From: Nicholas Donoghue [REDACTED]
Sent: 09 April 2021 15:21
To: Planning.Responses <Planning.Responses@arun.gov.uk>
Cc: Town Planning Southern [REDACTED]
Subject: Additional Network Rail comments: F/4/20/OUT - Land at Ford Airfield Ford

09/04/2021

**Network Rail Additional Consultation Response: F/4/20/OUT - Land at Ford Airfield Ford,
West Sussex**

FIGURE 23: KEY PRINCIPLES PLAN – PEDESTRIAN AND CYCLE MOVEMENT

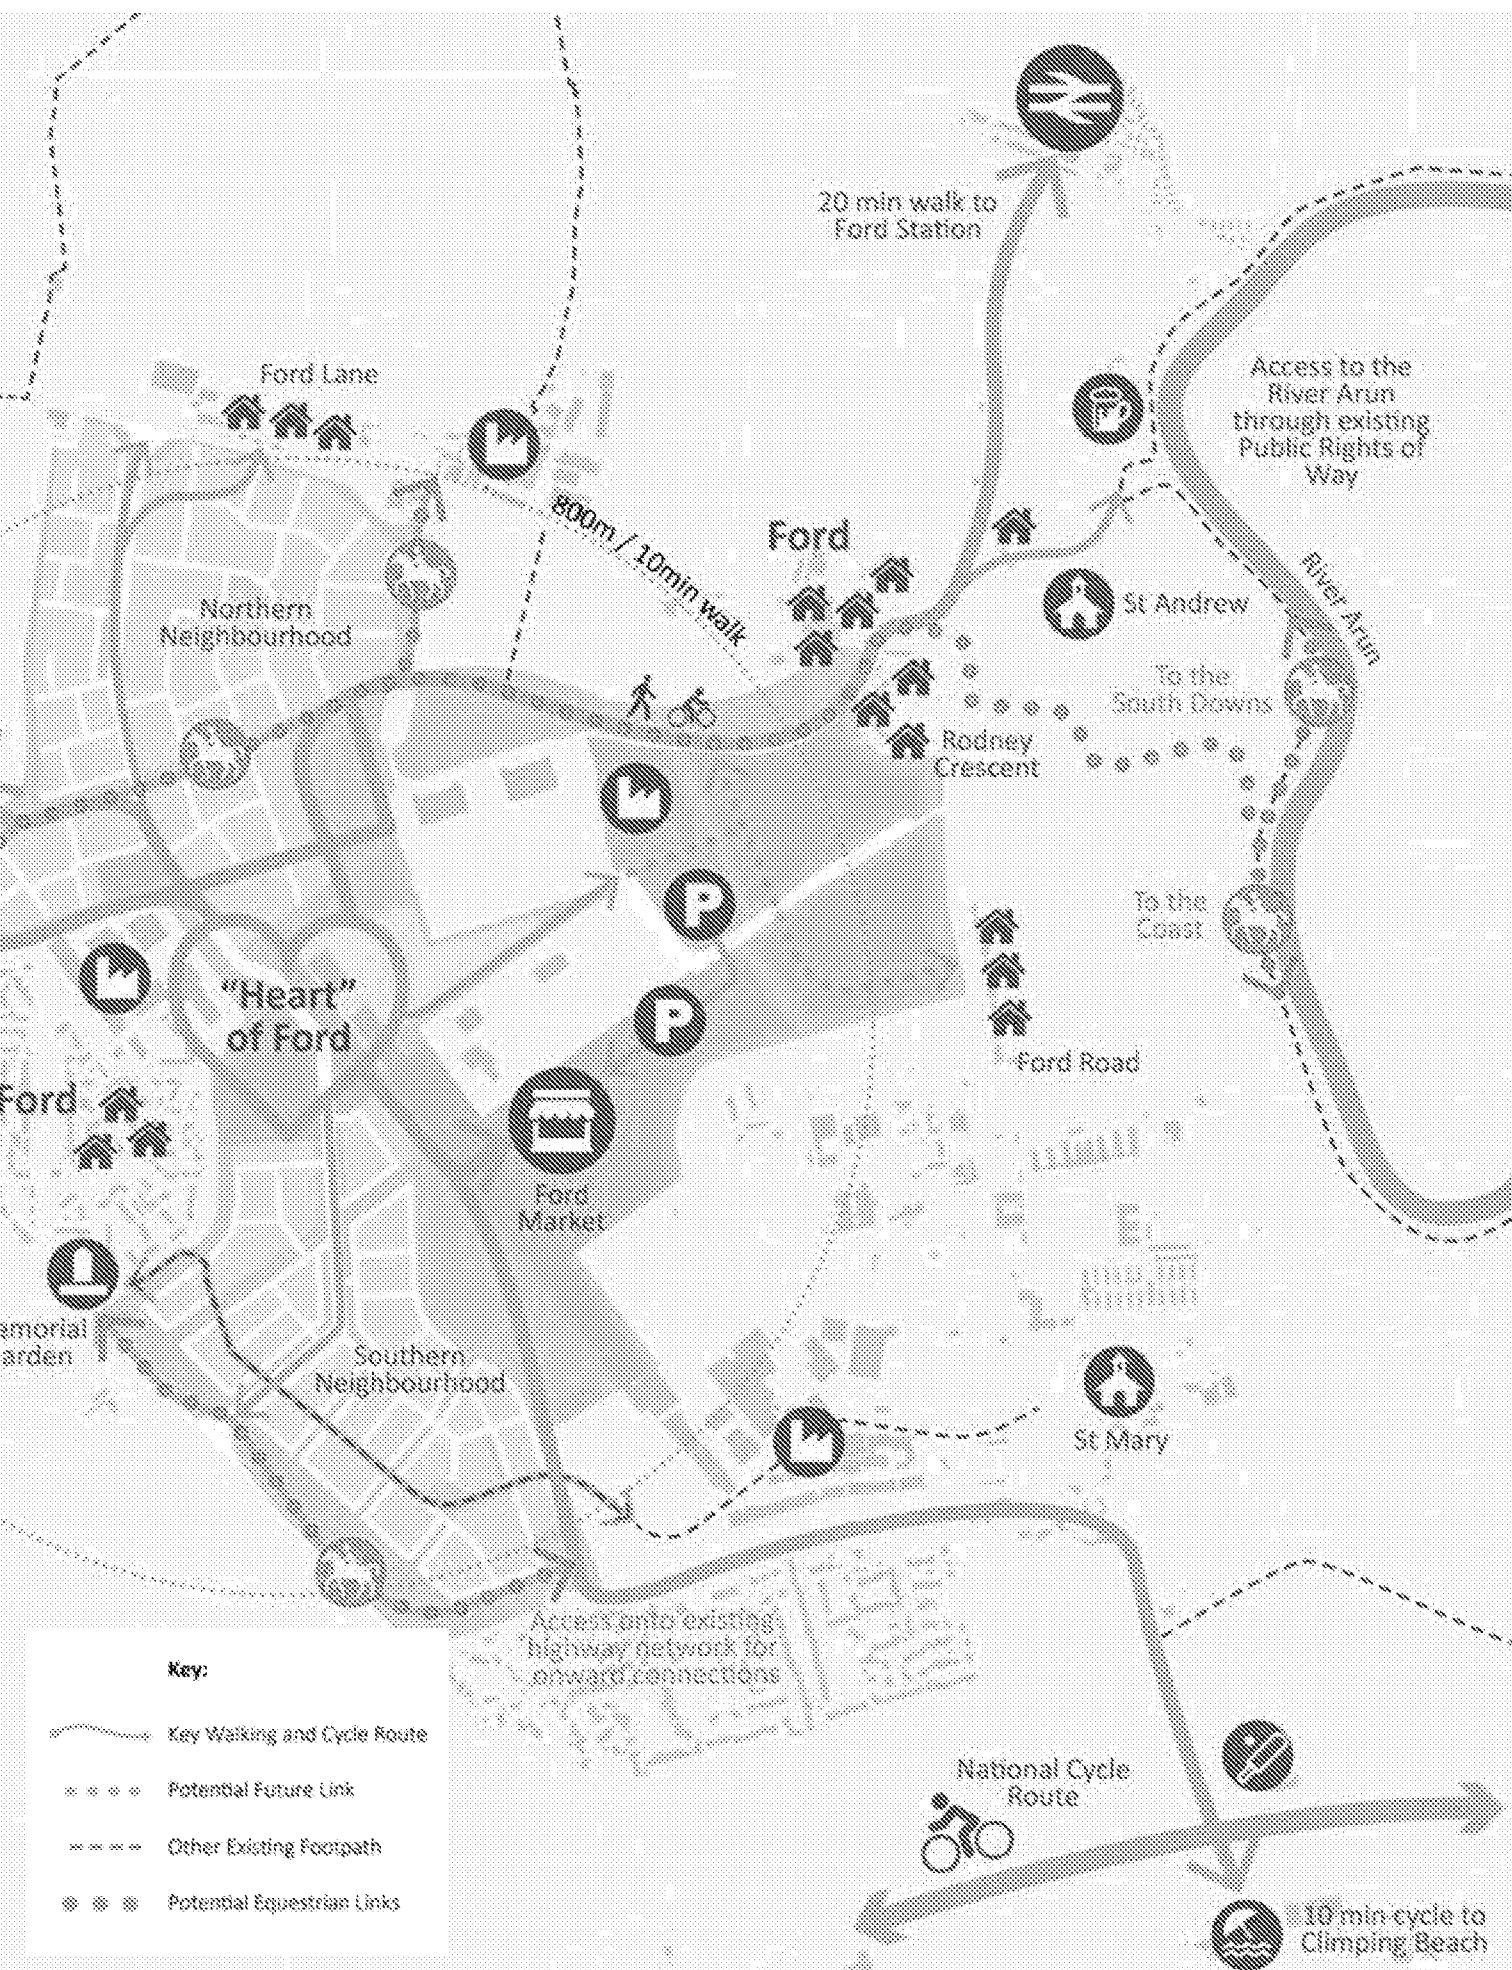
The distance from the development to Ford Station is borderline for either walking or driving and is a comfortable cycling distance and therefore efforts to increase the attractiveness of sustainable travel should be supported. Ford Station currently has poor access with a narrow footpath from the south and a busy road that is dangerous and unpleasant for cyclists.

To encourage active travel and promote sustainable transport in line with Policy T SP1 of the Arun Local Plan 2011-2031, there is a need for continuous direct and safe cycle and pedestrian route to link the new development with Ford Station. This new cycle path could also continue south to join National Cycle Route Network 2 (NCRN2) which consequently would link Clymping with Ford Station. The cycle and footpaths could continue north of Ford Station to provide a continuous direct and safe link to the centre of Arundel benefiting both tourists and residents.

As stated previously these cycle and pedestrian routes must be direct and continuous whereby they do not cross any roads. Where these routes pass over a road, vehicles must stop, give way and only proceed when clear of walkers and cyclists as shown in the photographs below.

- To provide continuous, direct and safe cycle and footpaths between the new development and Ford Station and incorporate into a Network that links with the centre of Arundel and NCRN2 (National Cycle Route Network 2).
- To provide a financial contribution to Network Rail to increase car parking and cycle parking at Ford station.
